**Marge Schmuckal - permit application 2013-00982 - shed**

**From:** Marge Schmuckal  
**To:** marioknox@gmail.com  
**Date:** 5/16/2013 4:50 PM  
**Subject:** permit application 2013-00982 - shed  
**CC:** Deb Andrews; Robert Wiener

APPLICANT'S APPLICATION FOR VARIATION KNOW

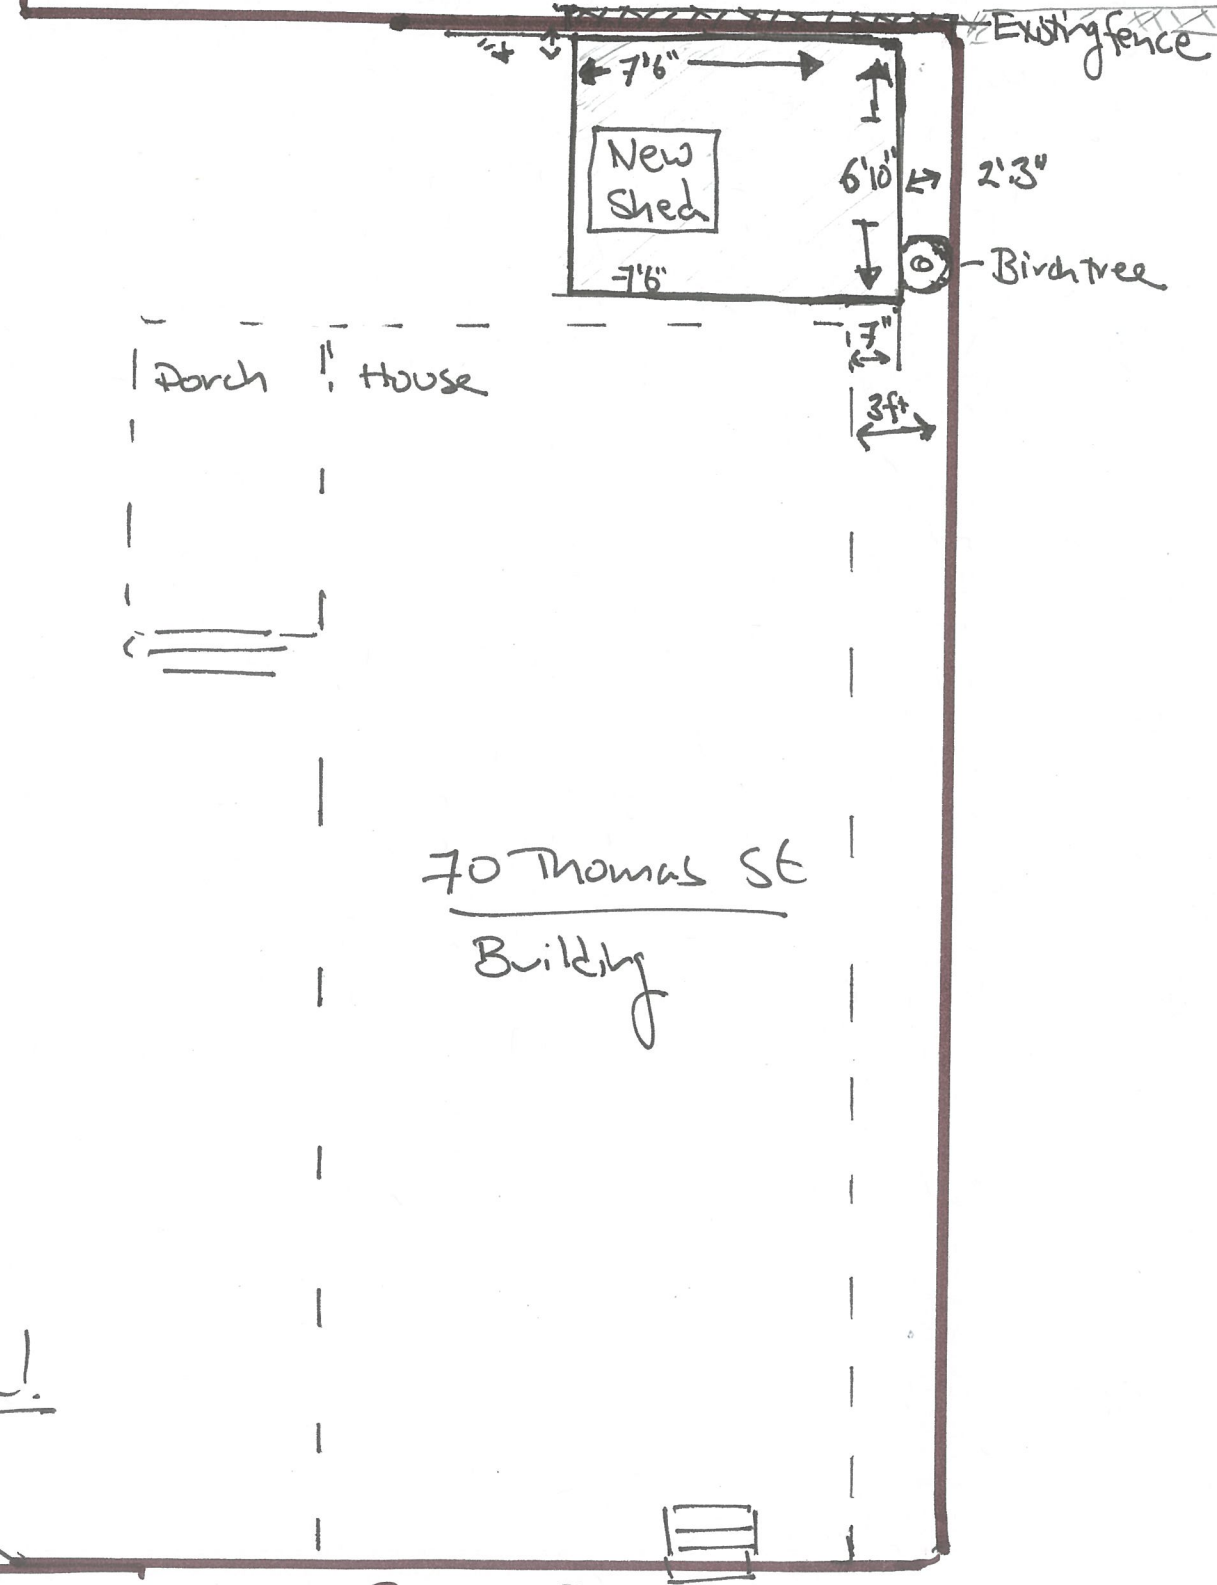
I am in receipt of your application to permit a 7'6" x 6'10" shed that has already been erected on your property. Your property is located in an R-6 residential zone which requires a minimum five (5) foot setback on the side and rear of your property [sections 14-139(a)4,b & c]. Your submission shows 4" and 3' as your setbacks. Your permit can not be approved as presently located. Your shed must be moved to meet the required setbacks or removed from the property. If you choose to move your shed, you must submit a new plot plan showing setbacks from the shed to your property lines. At that time I will re-review your application. Your new submission must be received no later than thirty (30) days from this date of notification (5/16/2013).
